FROM: Ian Gledhill TO: Arun District Council
FAO: Simon Davis

SUBJECT: P/58/15/OUT - Outline application with some matters reserved for the erection of 90 No. dwellings with associated access & open space. This is a Departure from the Development Plan.

Land at, Summer Lane, Pagham, PO21 4NG

DRAWING NUMBER: **120843/A/05** REVISION: **B**

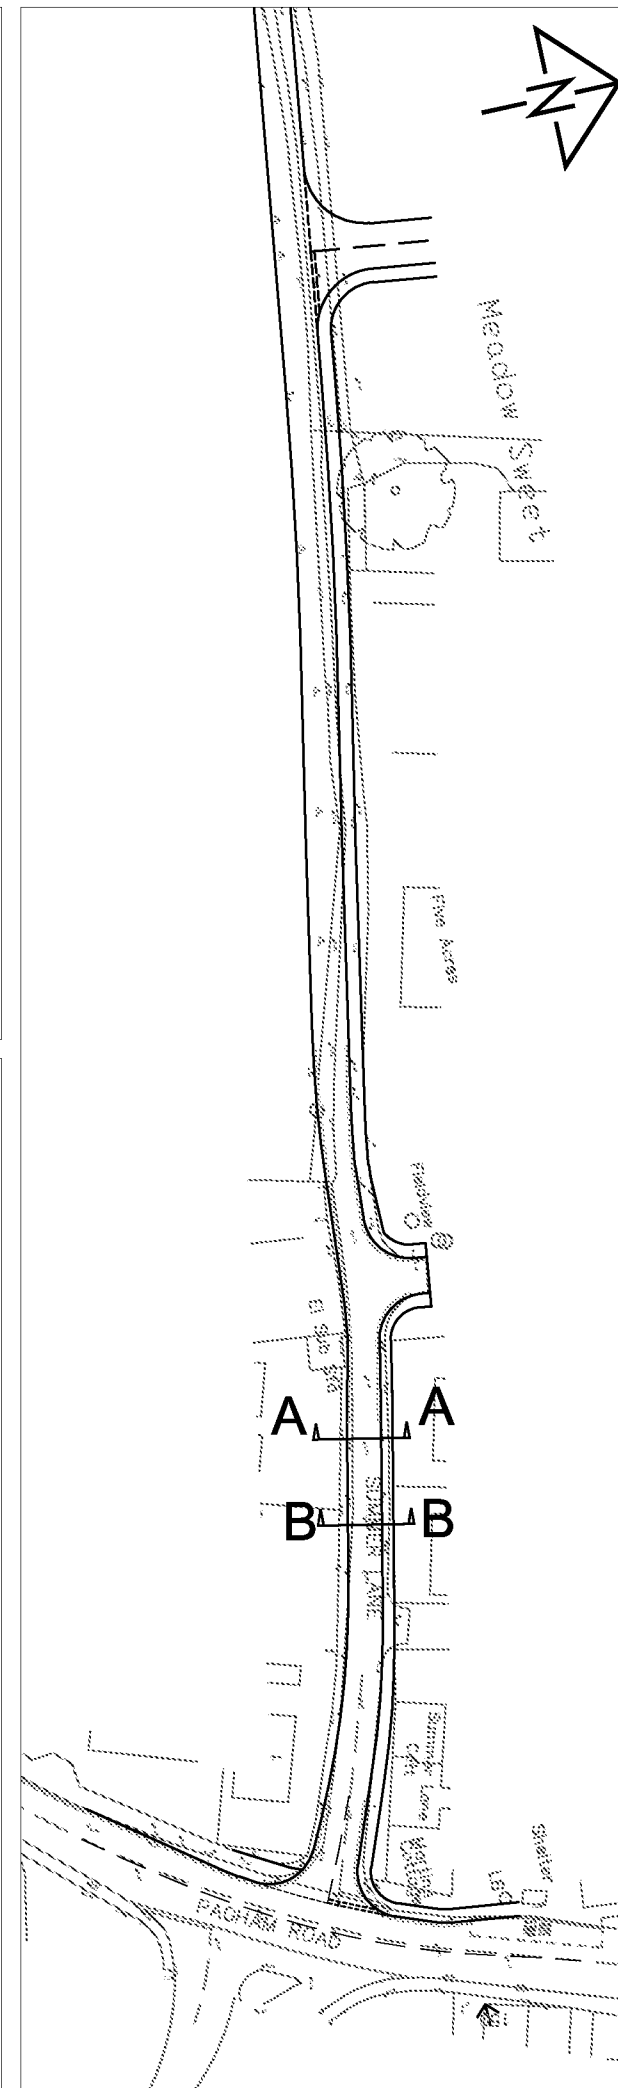
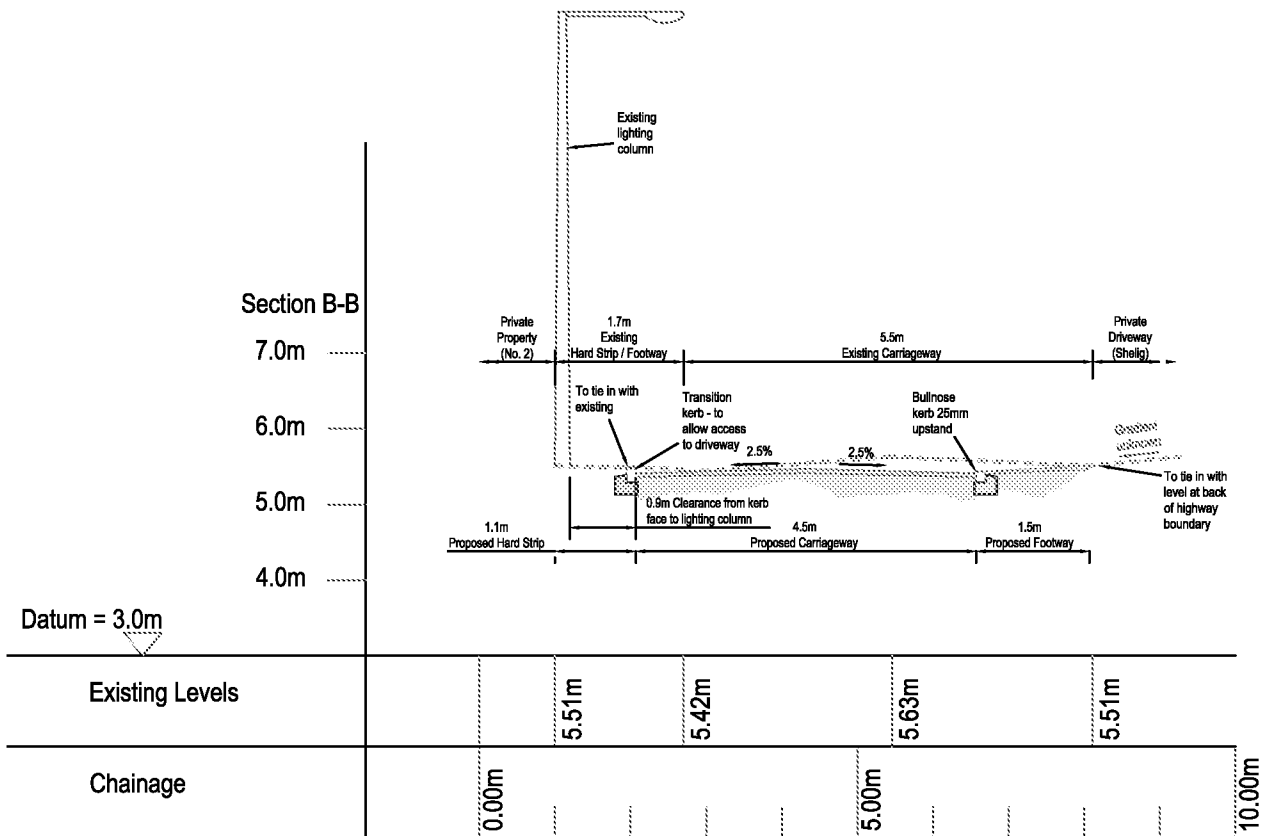
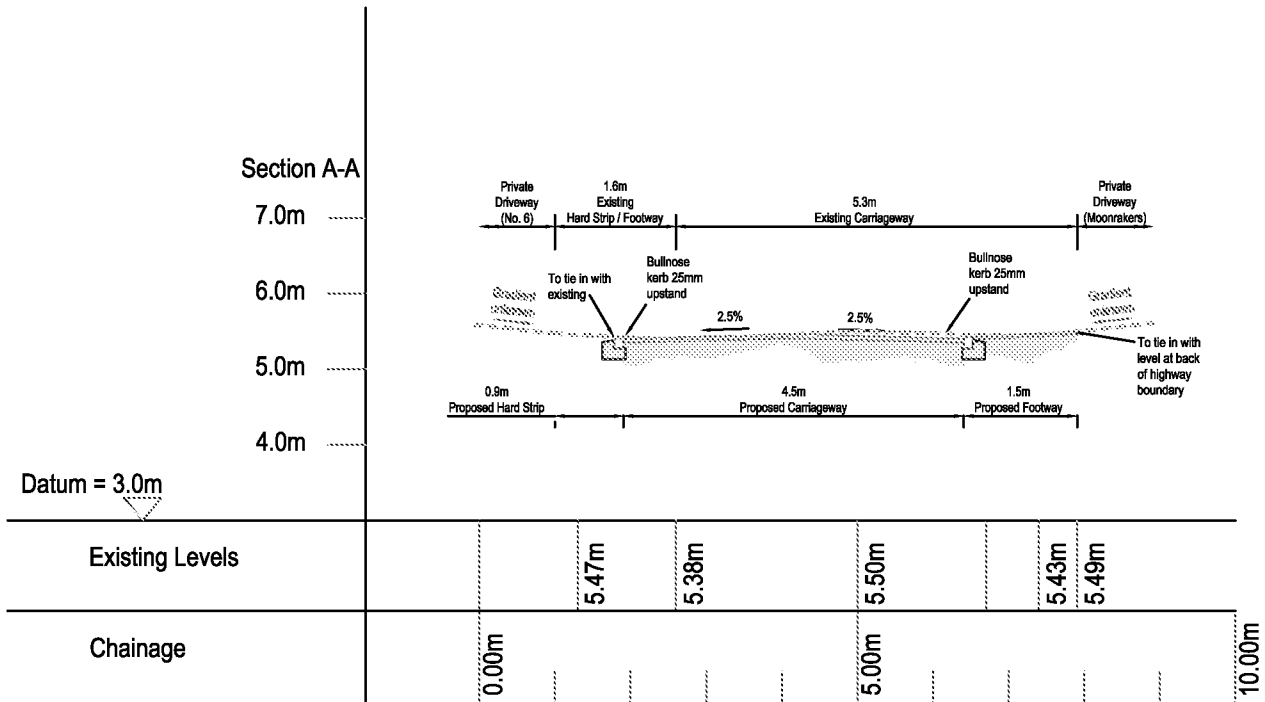
The applicant has confirmed that the eastern development access from Summer Lane will be widened to 4.8 metres. Visibility splays of 2.4 by 25 metres are shown at both junctions. The 25 metre element of the splays is based upon a design speed of 20mph. Given the constrained nature of the local highway network, this design speed and consequently the splays are considered appropriate.

A number of points were raised relating to Summer Lane. The proposed works have been revised. The revised scheme slightly widens the carriageway width (to 4.5 metres from the 4.1 metres previously shown) in the vicinity of the eastern access. This widening is at the expense of the proposed footway width, although this still retains a width of 1.5 metres. Even with the additional development, Summer Lane will be lightly trafficked and low speed. The proposed carriageway and footway widths at this location reflect only a pinch point where a consistent 4.8 metre carriageway and 1.8 metre footway are provided. In light of the constraints in this location, the widths are considered appropriate.

Key:
Ex:16.71m Existing Visibility
Pr:16.71m Proposed Visibility

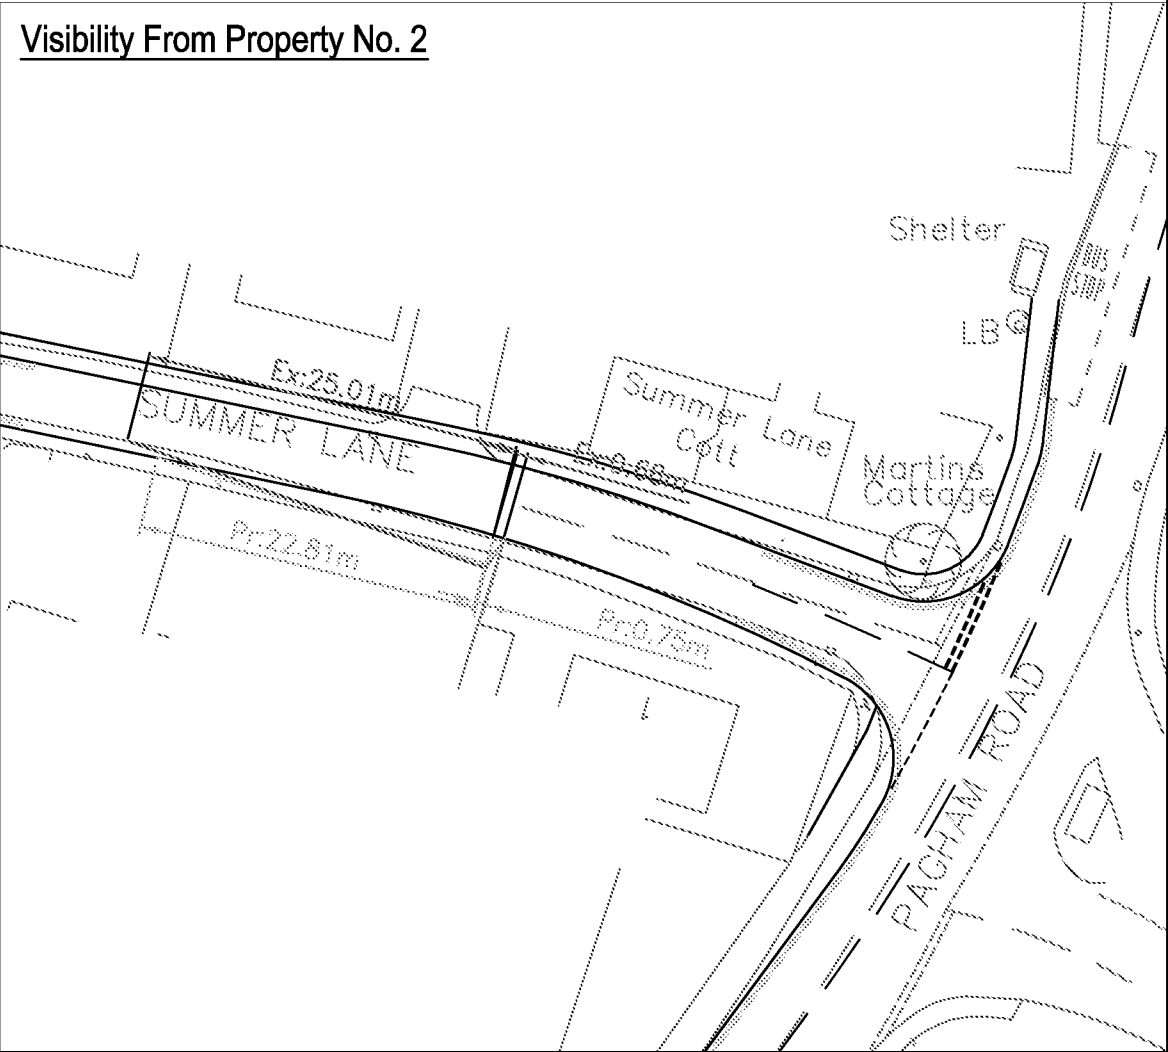
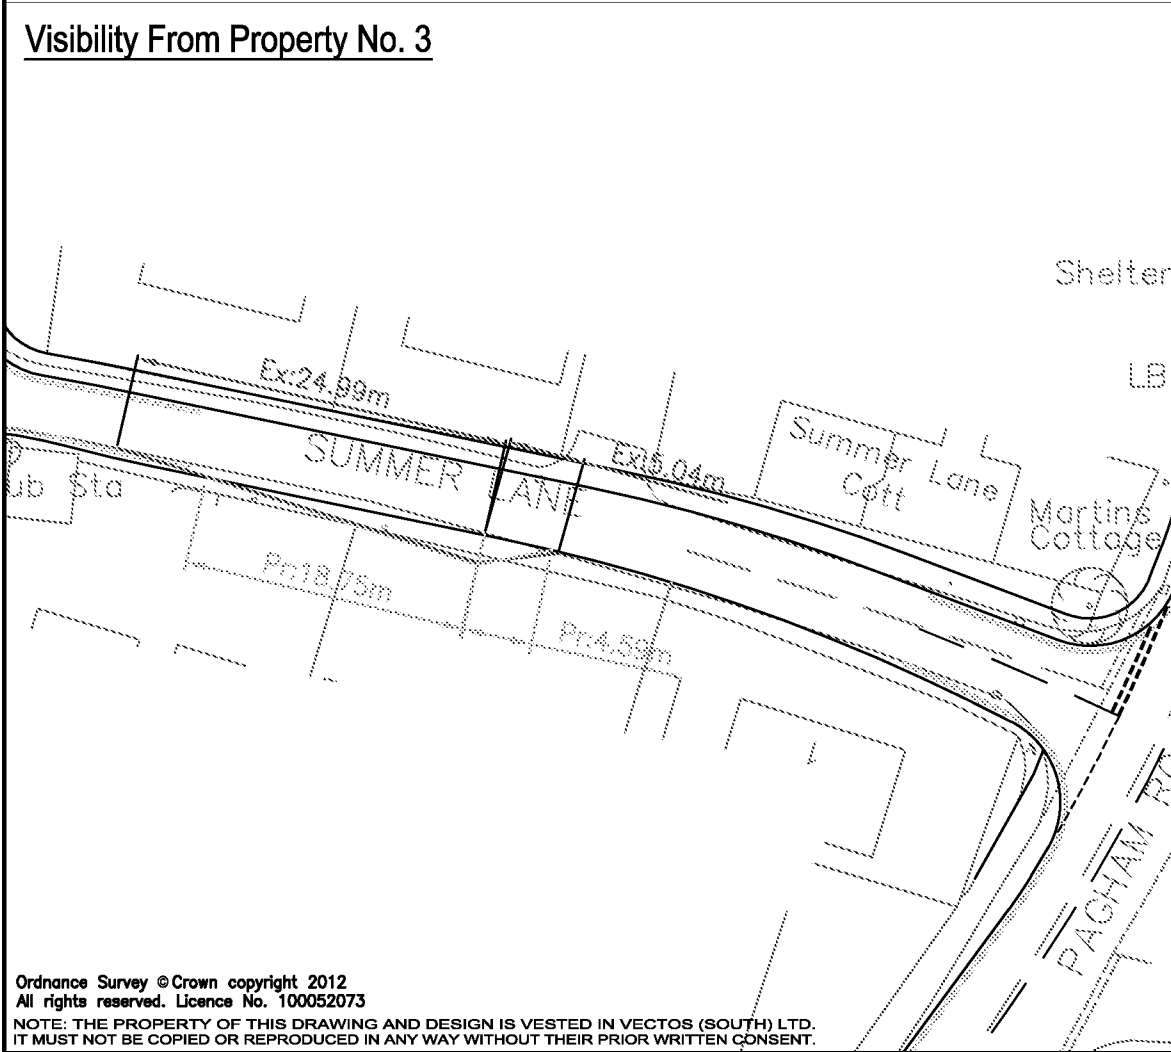
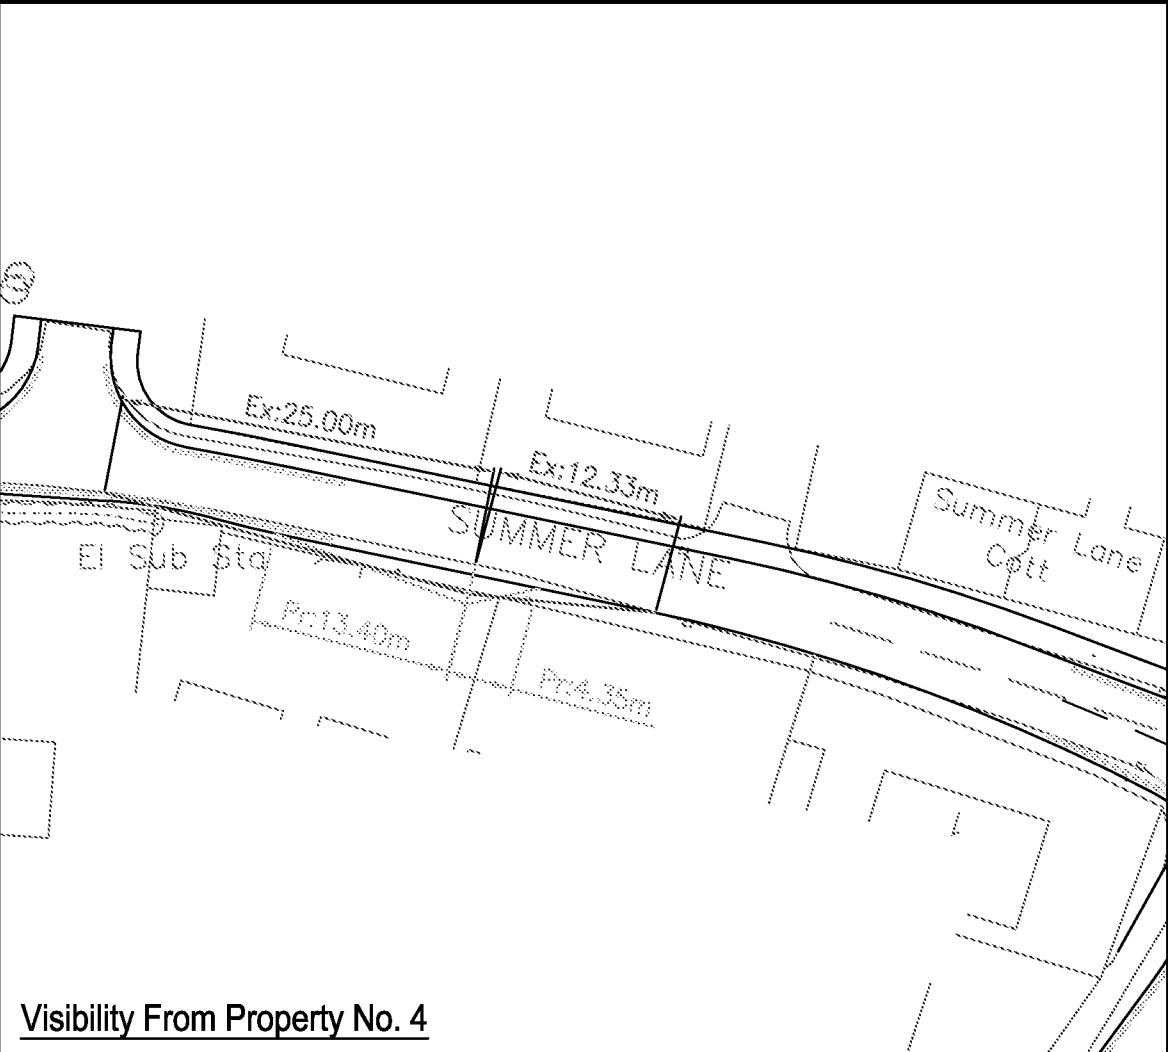
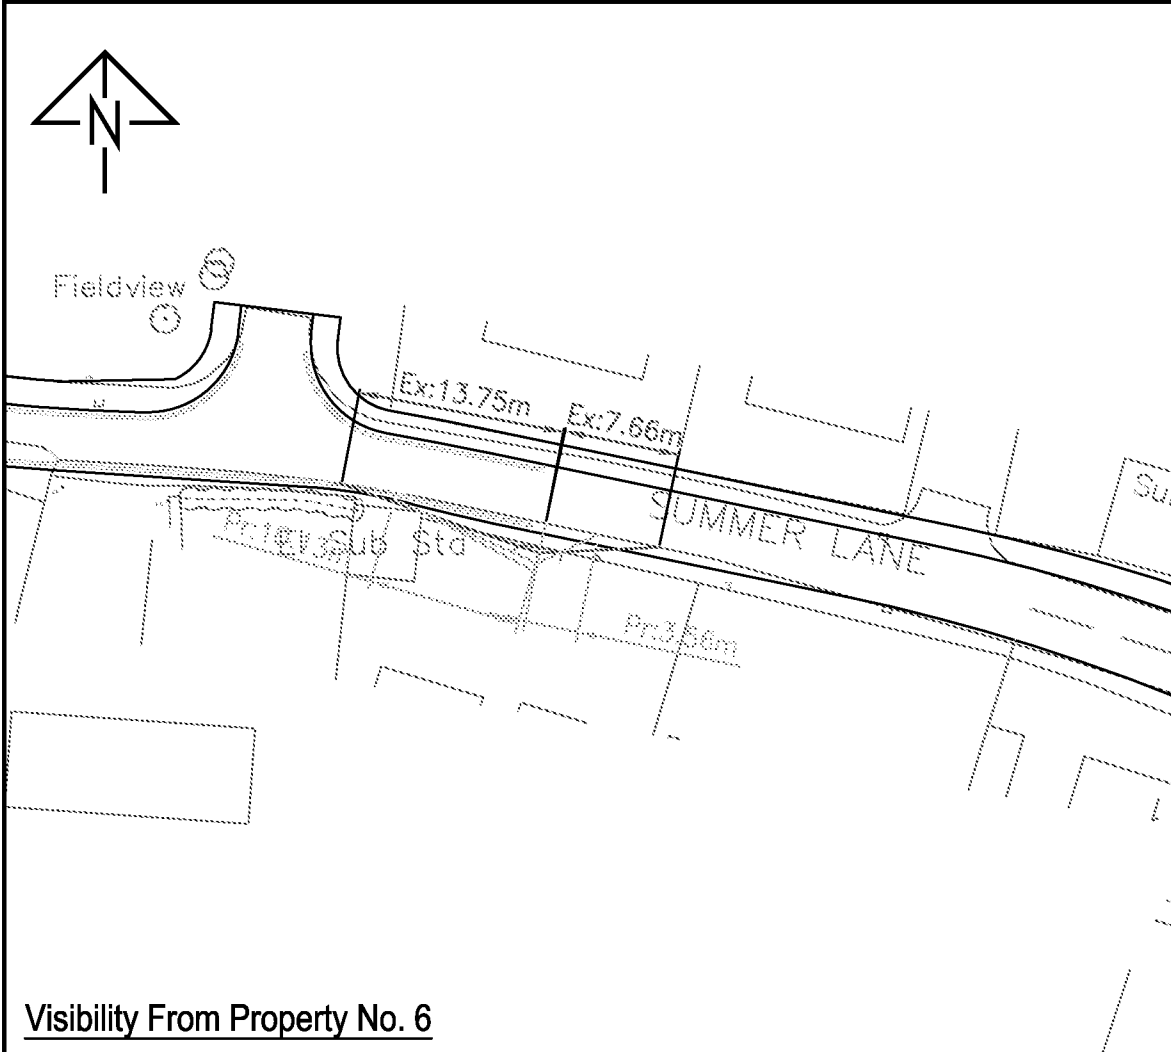
The implications on visibility from existing driveways on the south side of Summer Lane as a result of relocating and widening of the footway to the northern side has been considered in greater detail. The results of this indicate that visibility will be worsened although at most of the accesses visibility is already substandard. The visibility splays for each of the properties has also been drawn within the extent of the public highway and the curtilage of the respective dwelling. All of the dwellings in question presently have open frontages, permitting visibility over the adjoining land. Whilst occupiers of these dwellings may erect fencing or seek to enclose their front gardens, in practice this is perhaps unlikely given that it would then severely constrain visibility from their own respective access.

The views of an independent road safety auditor have been sought in respects of the matter of reduced visibility. They have confirmed that on balance they consider the overall road safety impact to be neutral given the benefits of other works proposed. It is also noteworthy that the Stage One Road Safety Audit provided with the application raised no problems or concerns regarding reduced visibility at the existing southern accesses caused by the proposed highway works.

The potential reduced visibility from the existing southern access points is acknowledged. Conversely though, visibility at the accesses on the northern side of Summer Lane will be improved. Taking the evidence available and the overall benefit from the highway improvements, on balance these are considered to be acceptable.
